**CONFIDENTIAL Submission to the Parramatta Light Rail (Stage 2) SSI-10035**

This submission is prepared by *Keylan Consulting Pty Ltd* on behalf of PAYCE (client) in response to Transport for NSW's (TfNSW) *Parramatta Light Rail Stage 2* (PLR) State Significant Infrastructure (SSI) application which is on exhibition until 16 December 2022.

Figure 2.4 Project site – map 3

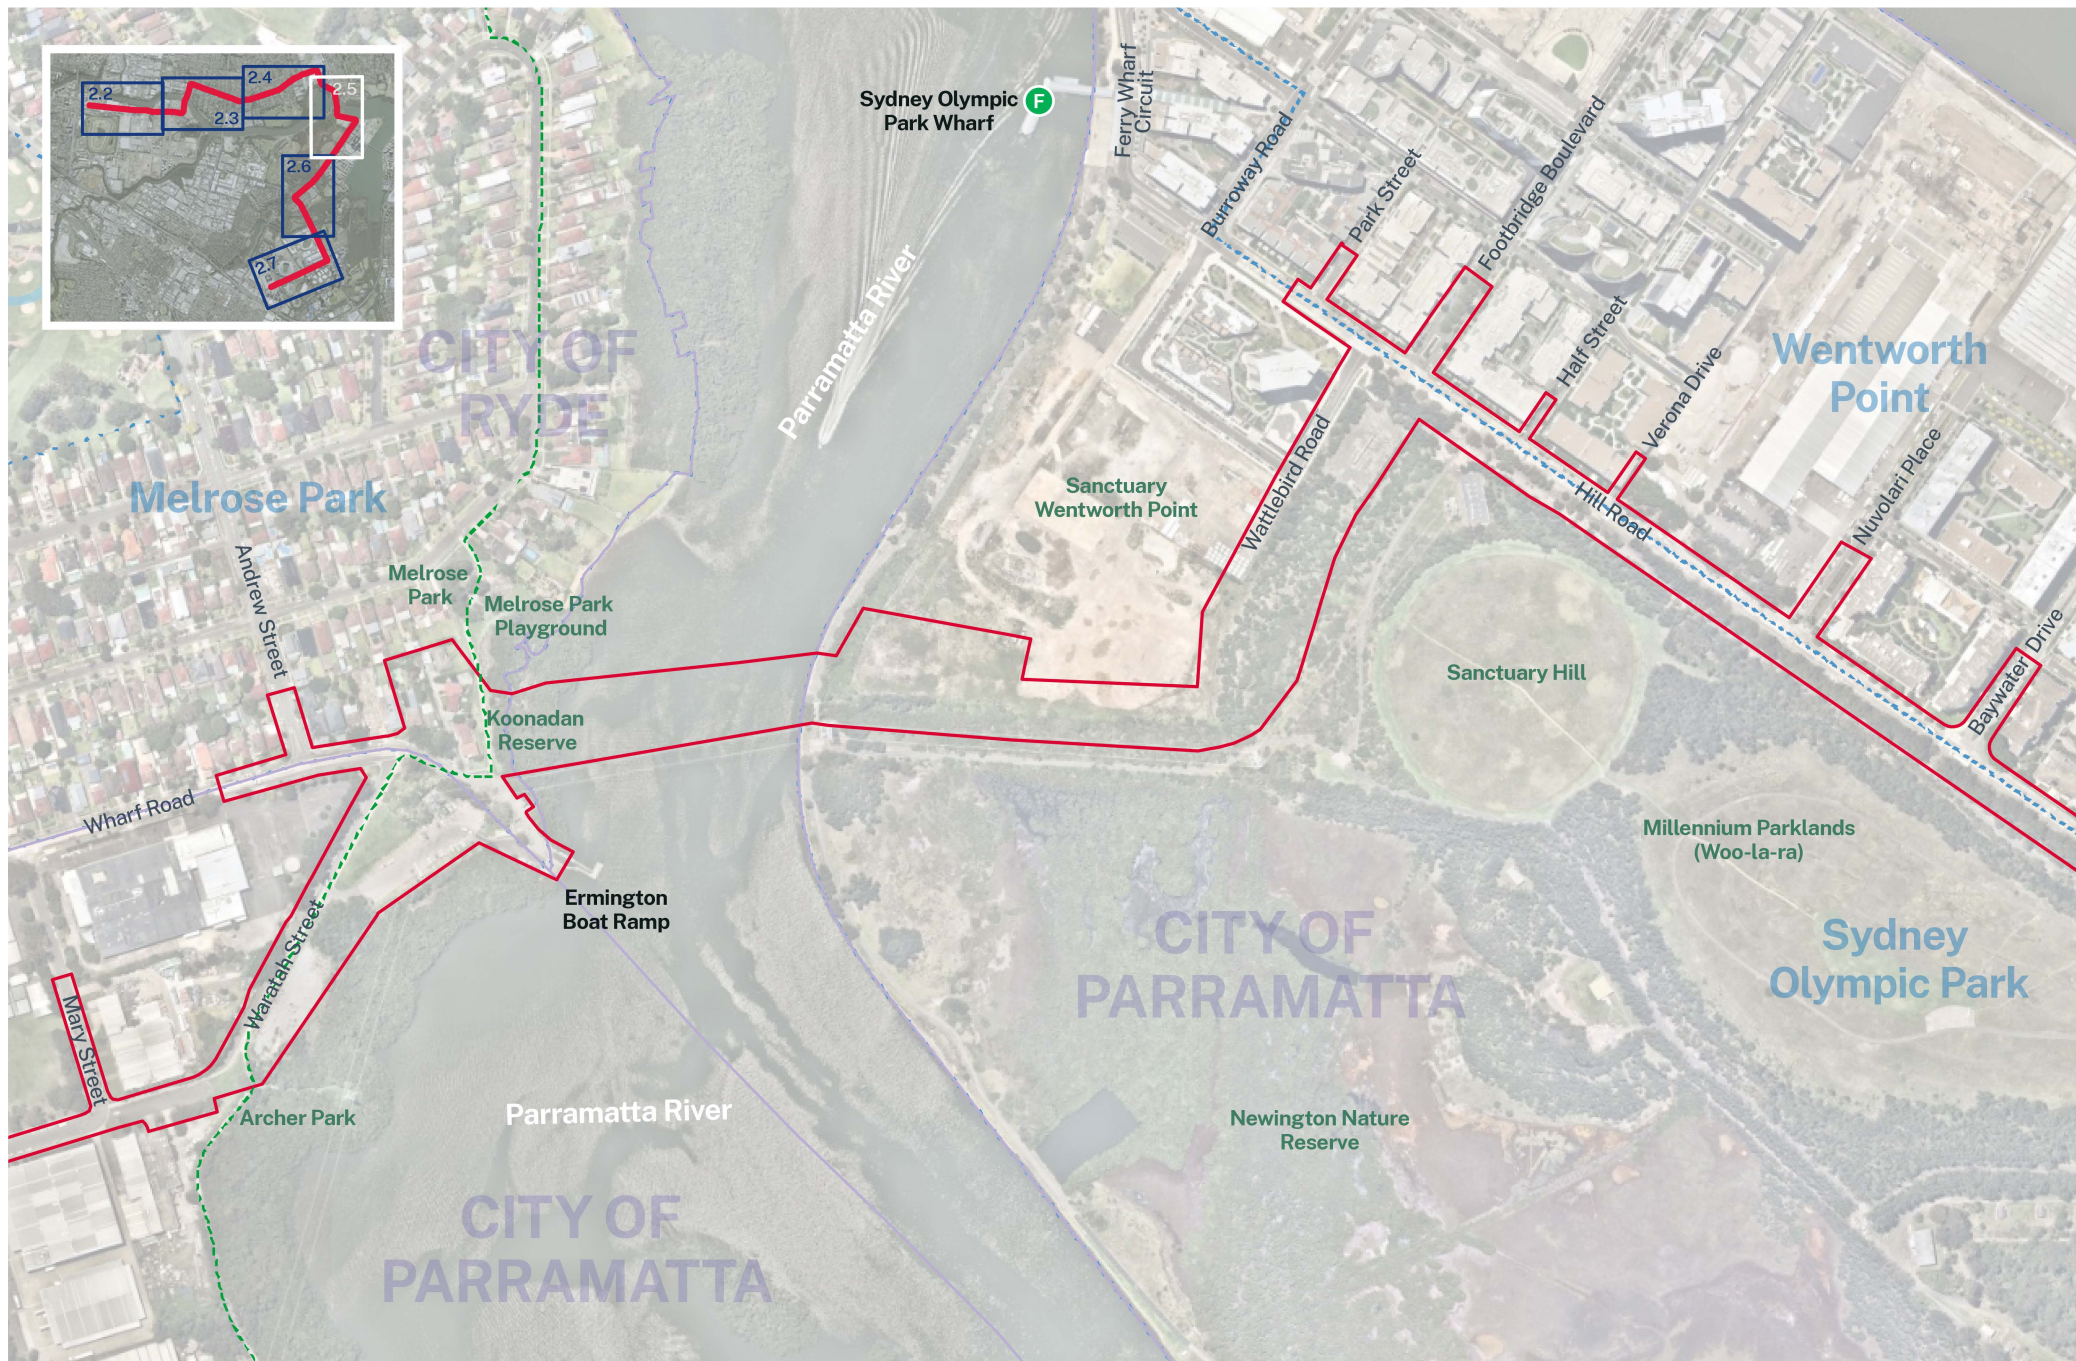
Figure 7: Extract of PLR project site map 3 with site outlined in YELLOW (Source: DPE, EIS)

A large portion of the Tomola site is identified within the “Project Site” as shown in Figure 7. For clarity the Tomola site is outlined in yellow while the project site is outlined in red.

These generous setbacks restrict the building footprint to a relatively small area, however, the EIS and supporting documentation fail to consider these proposed setbacks and continue to reserve far more land than deemed necessary.

Overall, it is considered the EIS and supporting documentation does not adequately justify the extent of the *Project Site* area.

In particular, no rationale is provided as to why such a large portion of the Tomola site is identified within this area. It is requested that future clarification be provided on the rationale of the proposed acquisition.

As already indicated, the Tomola Site will be accessed from Hughes Ave and will not impact the proposed PLR route. It is recommended that the draft project land requirements be reduced to be consistent with the corridor proposed for the Town Centre to the east, namely a 12m setback requirement, as identified in Figure 8.
